Project Name: Bampton Estate  
 Document Date: 12.01.2024  
 Document No: 93-BMT-SBA-00-ZZ-CL-A  
 Document Name: Hard Landscaping, Planning Condition 15 – Hard Landscape Material, Kerbs  
 Prepared By: Jeremy Randall (GML) 12.01.2024

## Bampton Estate, Lewisham // Application to discharge Condition 15, Hard Landscape

We hereby seek to discharge Condition 15 – Hard Landscaping Phase 2 attached to planning consent DC/19/112918 amended under DC/21/123804.

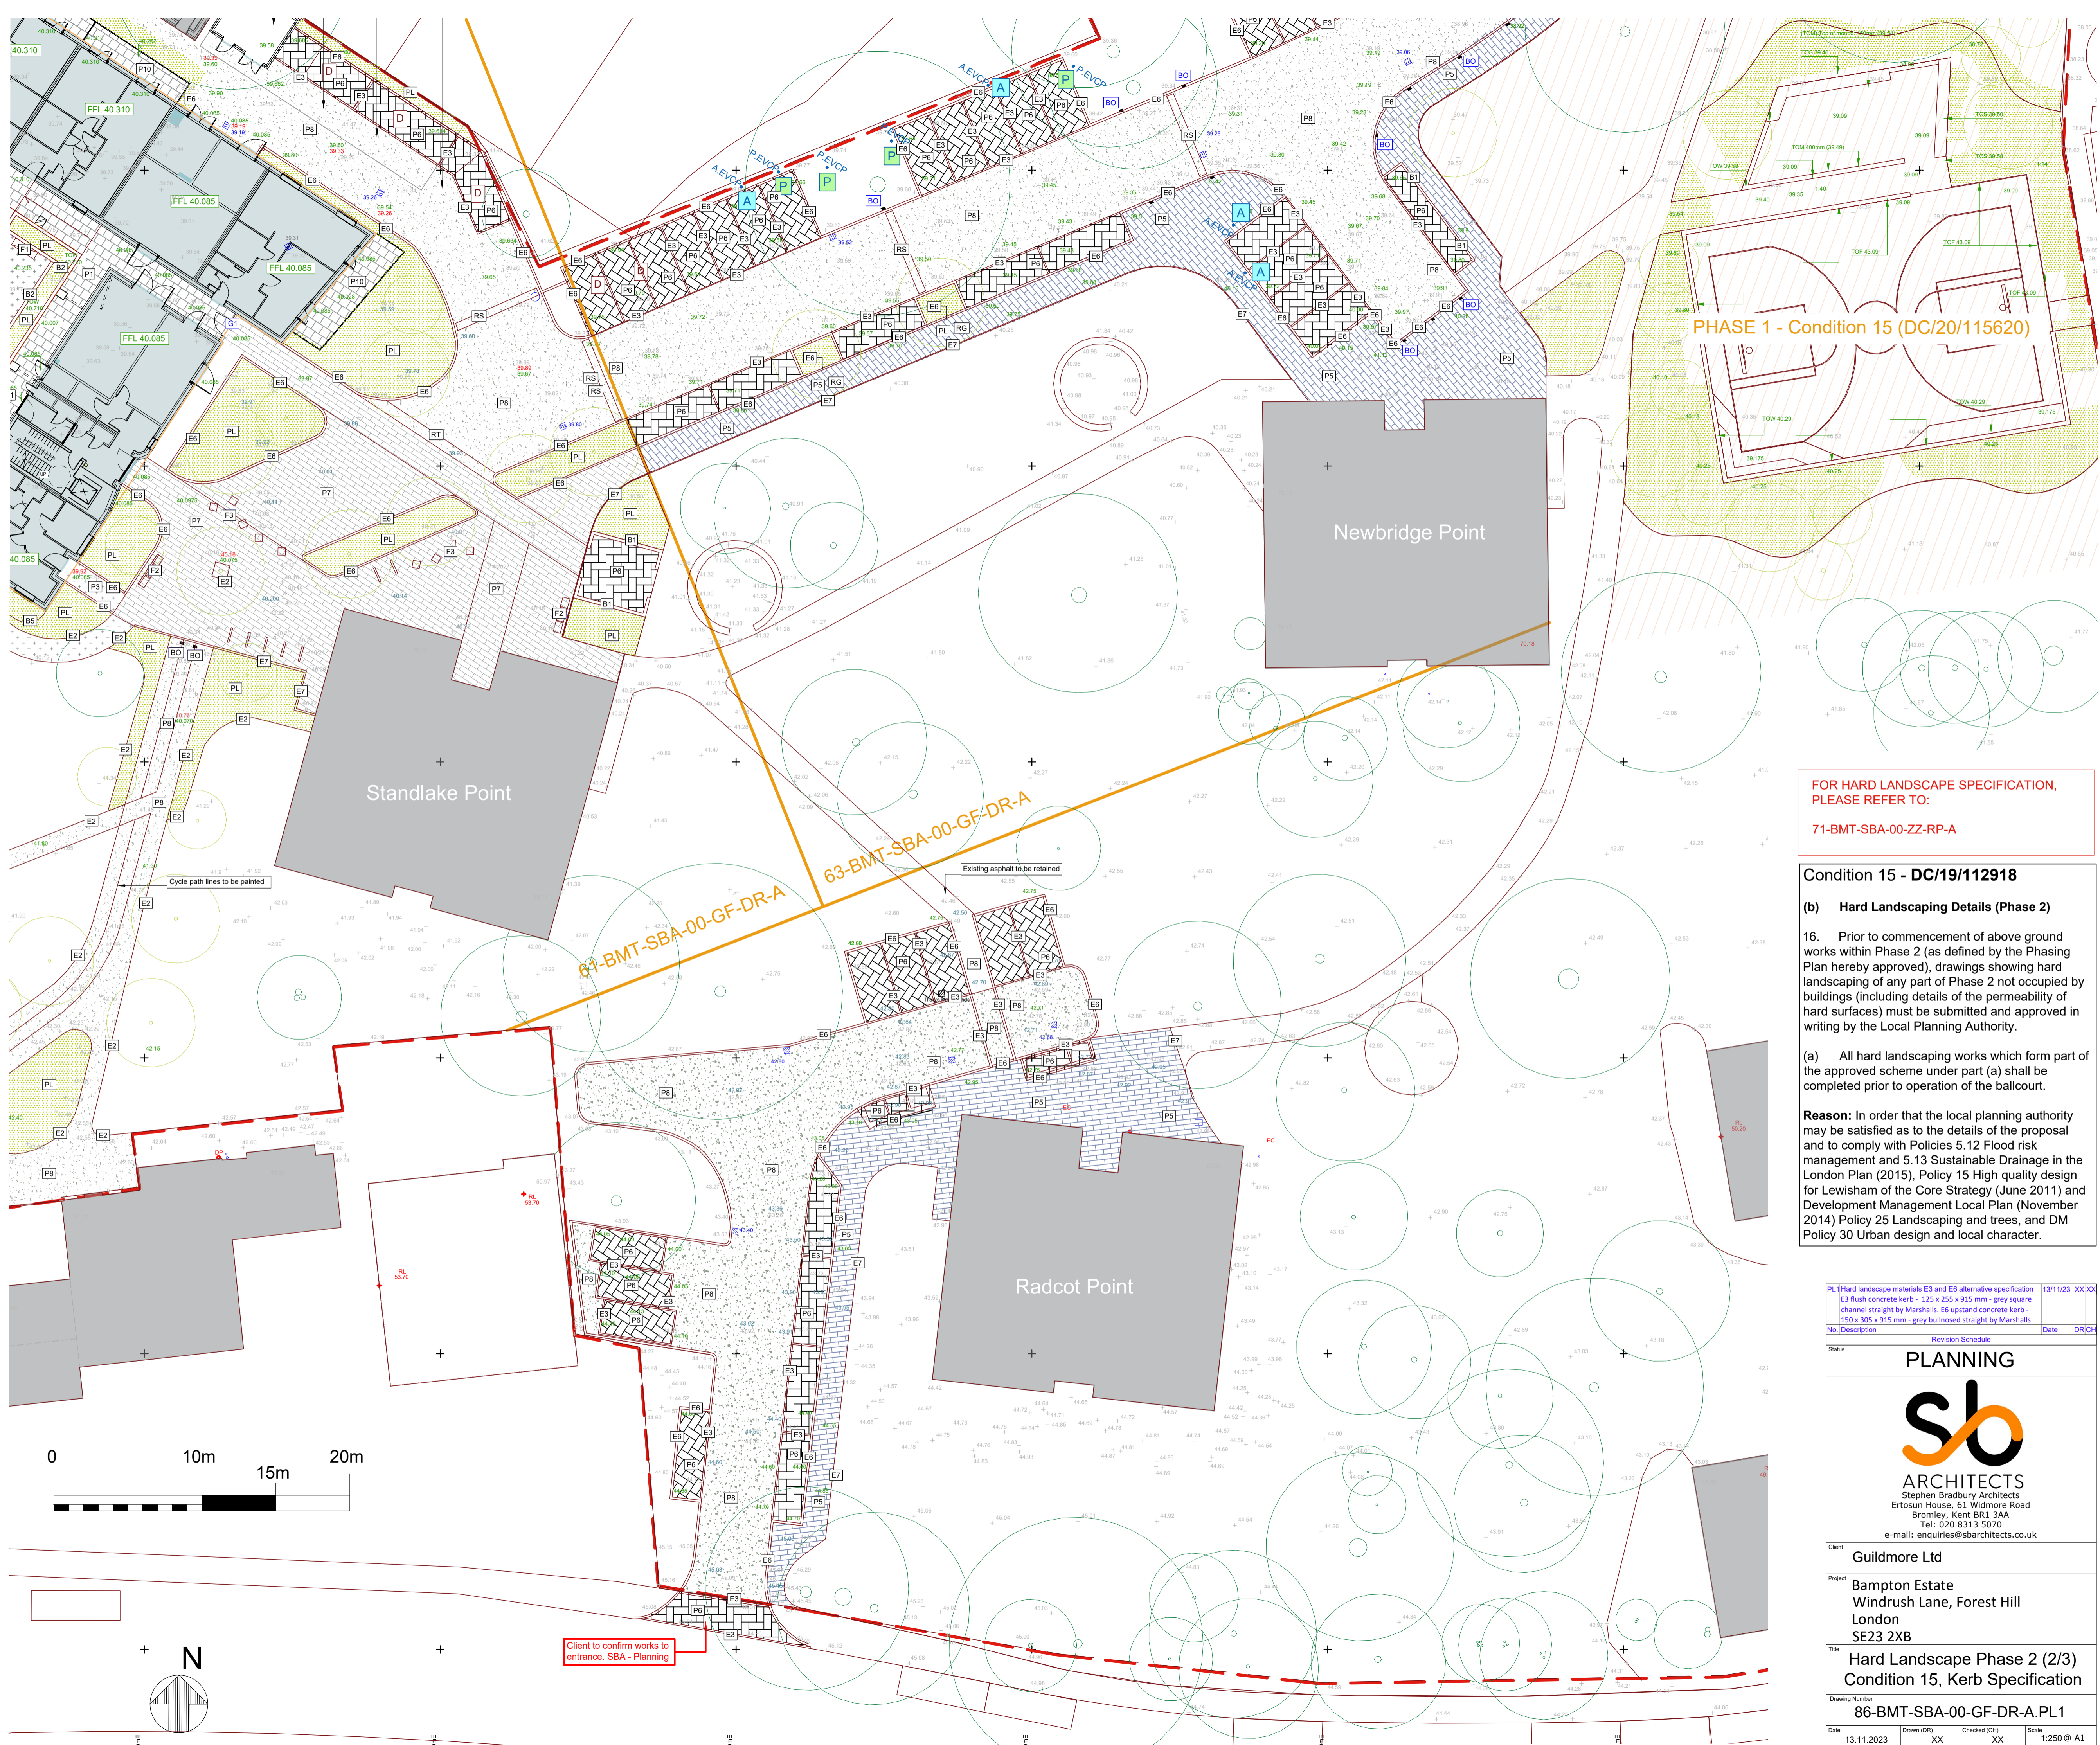
We are applying to have an alternative material specification approved for landscape materials E3 flush kerbs and E6 upstand kerbs.

Have a specification for E3 and E6 as

E3	FLUSH NATURAL KERB GRANITE - 125 X 250 X 1000 MM - SILVER GREY FLAMED BY AGGREGATE INDUSTRIES
E6	UPSTAND NATURAL KERB GRANITE - 150 X 300 X 1000 MM - SILVER GREY FLAMED BY AGGREGATE INDUSTRIES

We are requesting that the alternative material specification as shown on the submitted drawing be approved.

The reason for the requested alternative material specification is that concrete kerbs have been installed by the sub contractor at Bampton Estate to match existing materials on site. The workmanship is of good quality and the material hard wearing in accordance with highways specifications. Removal of these and replacement with granite would be unnecessarily disruptive and wasteful.

E3	FLUSH CONCRETE KERB - 125 X 255 X 915 MM - GREY SQUARE CHANNEL STRAIGHT BY MARSHALLS
E6	UPSTAND CONCRETE KERB - 150 X 305 X 915 MM - GREY BULLNOSED STRAIGHT BY MARSHALLS
